Submission to NSW Government, Planning and Environment
Application No SSD 8126 Redevelopment of Cliffbrook Campus, 41-25 Beach Street, Coogee

FT02C Eastern Stair Facade

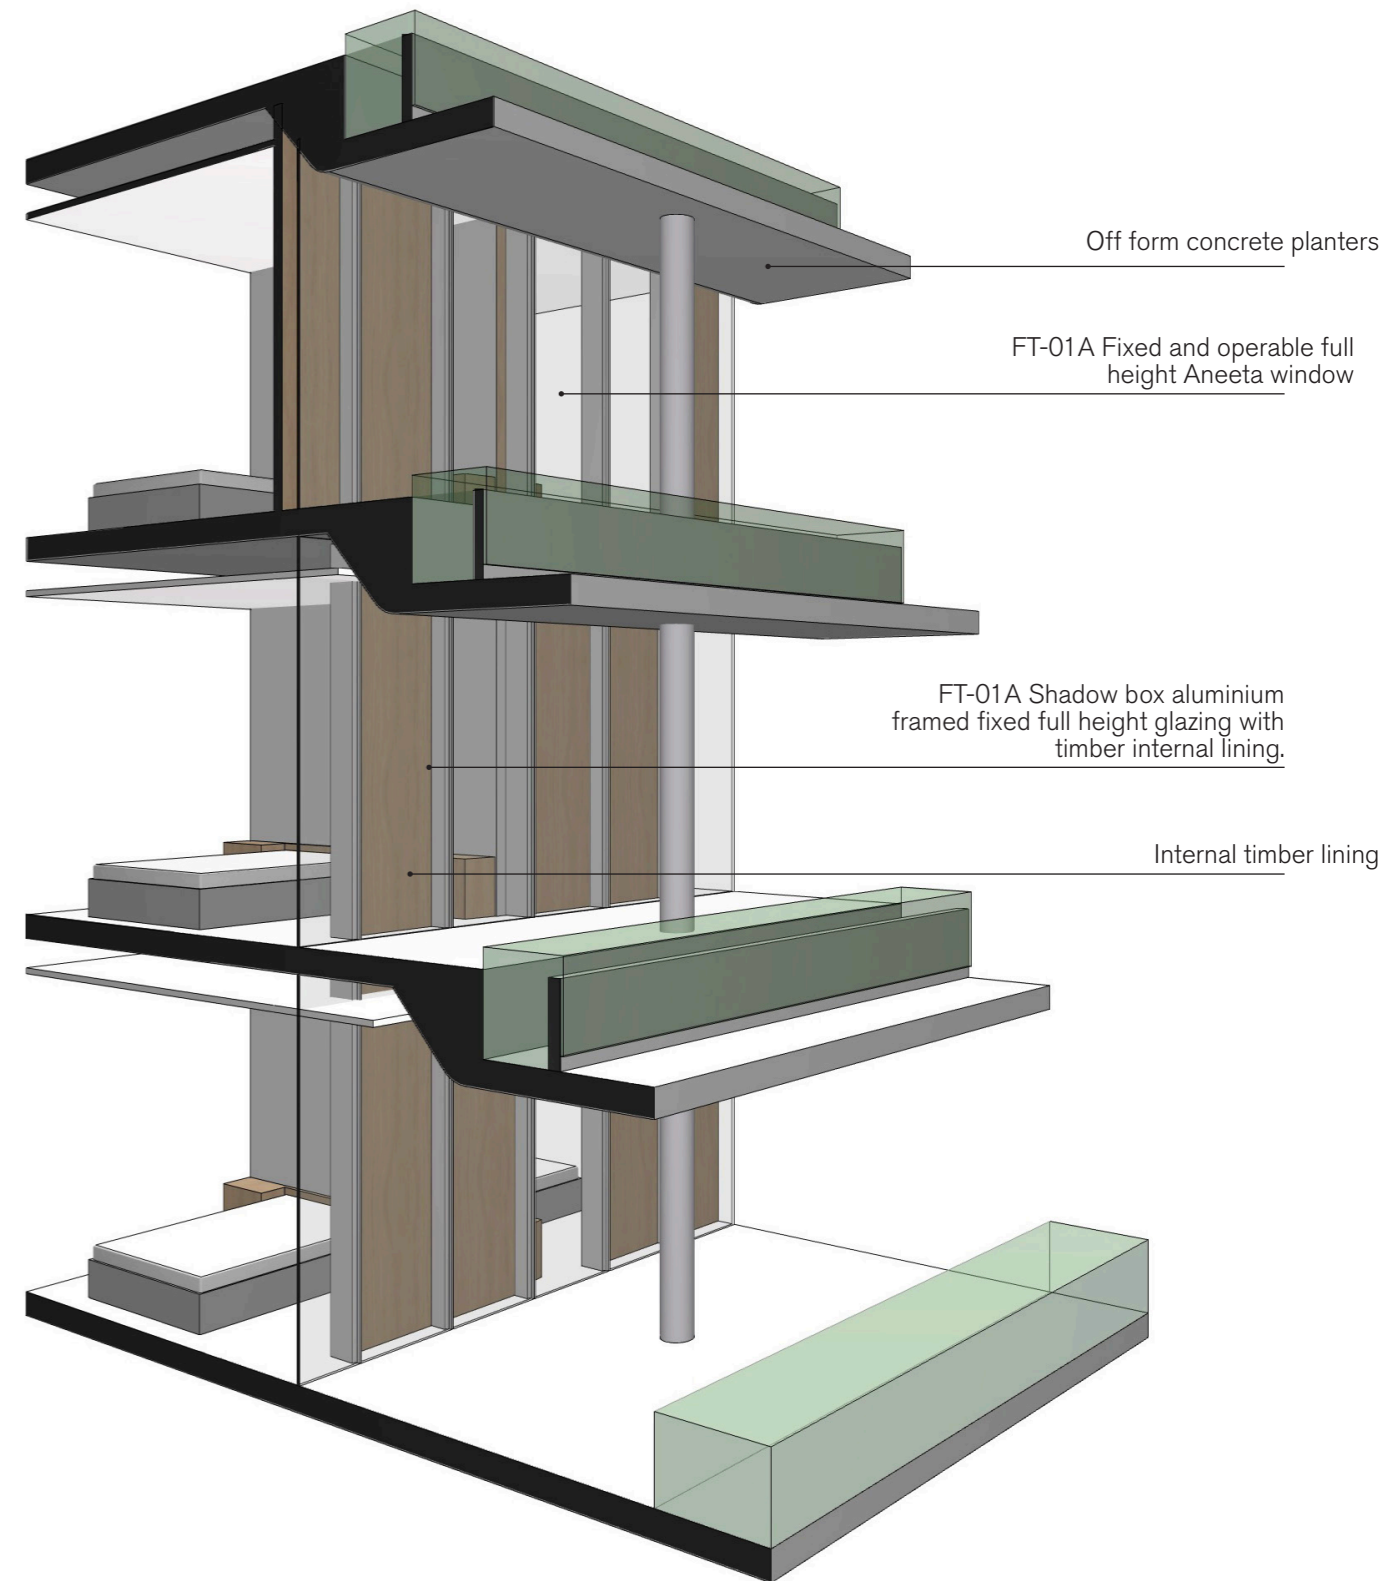
e) We note that the stairwells facing Battery St do not have wooden slats. The result of this will be glare from lights on during night hour from the stairwells. We would appreciate the wooden slat effect to be continued across the stairwell windows.

5 PLAN Level 3
1:500

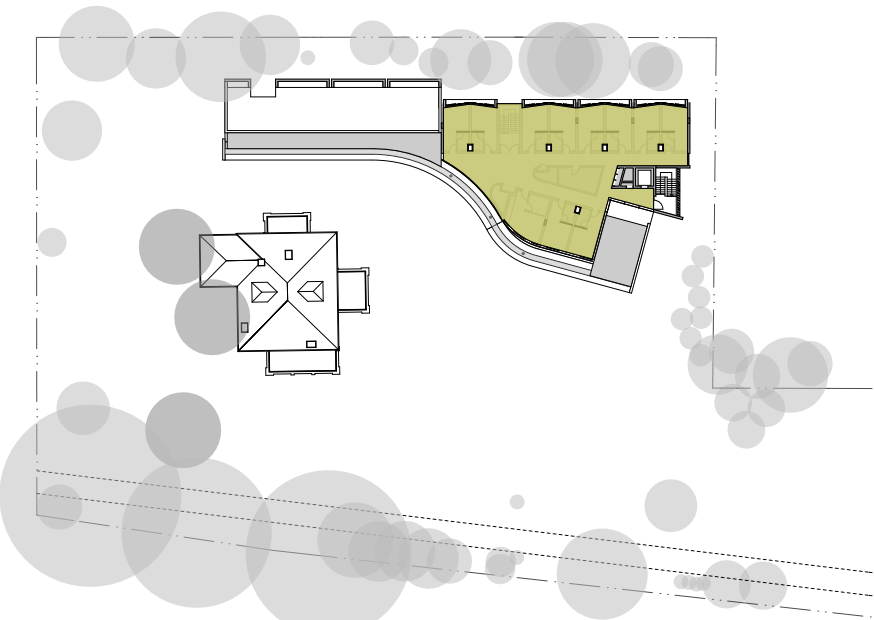
b) The bulk of the building on Level 3 running along Battery Street will impose view and light restrictions on our property.
